Arun District Council
Arun Civic Centre
Maltravers Road
Littlehampton
West Sussex BN17 5LF
Planning & Building Control General Enquiries
Tel: (01903) 737756 Fax: (01903) 730442
Dx: 57406 Littlehampton
Minicom: 01903 732765
e-mail: planning@arun.gov.uk
website: www.arun.gov.uk/planning

28th June 2021

Application No: M/76/21/HH
Site Address: 38 Sea Way Middleton-On-Sea PO22 7SA
Description of works: Erection of two storey side and rear extension and single storey front extension with balcony above

PROJECT TITLE Proposed Development at 38 Sea Way Middleton-on-Sea Bognor Regis	DRAWING TITLE Proposed Site & Location Plan		No	REVISION	DATE
	STATUS Planning Application				
	SCALE as noted @ A3	DATE 04/05/2021			
	DRAWN BY DE	DRAWING NO PA-361-10

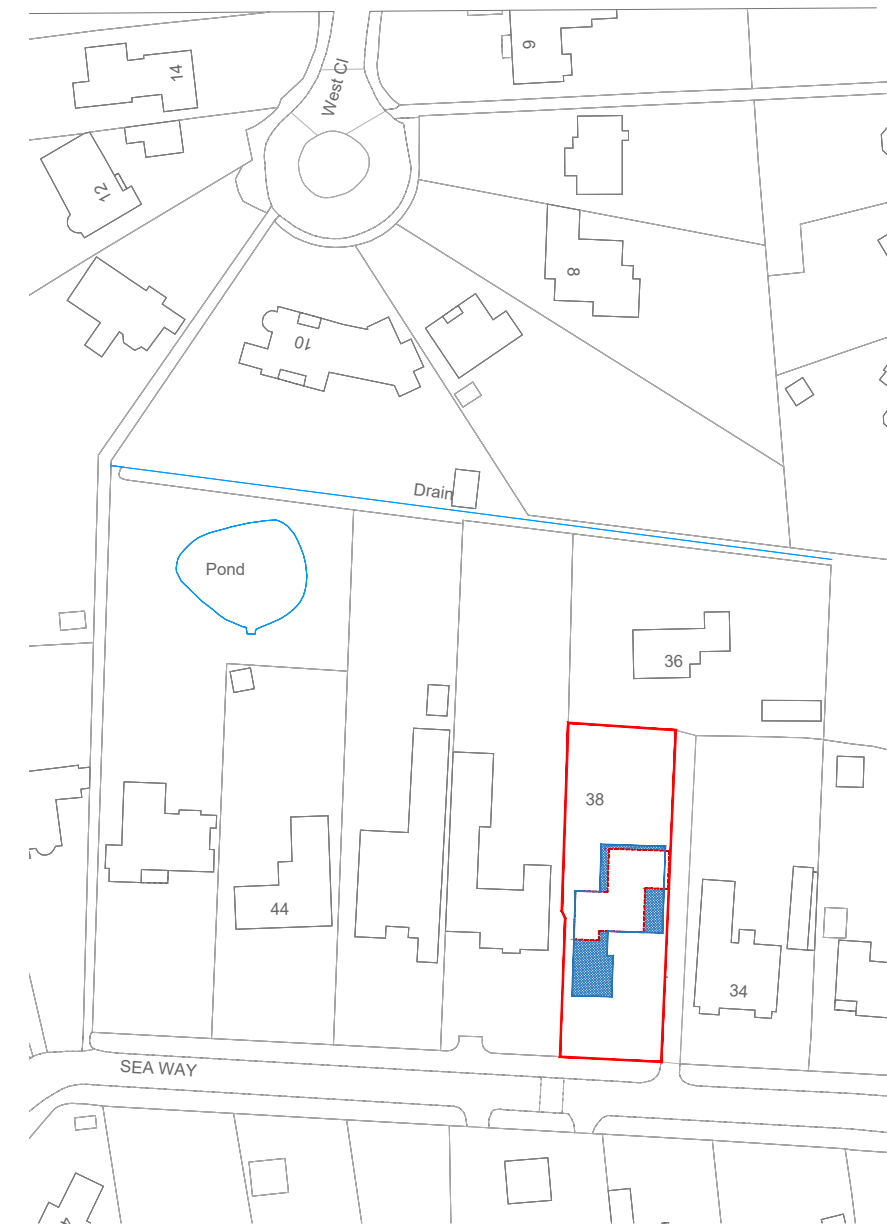
Whilst MoSA have no objection to the development proposed, we note that the submitted plans indicate a significant widening of the driveway. ADC are advised that this will encroach onto MoSA land and will require MoSA's formal agreement which may or may not be forthcoming.
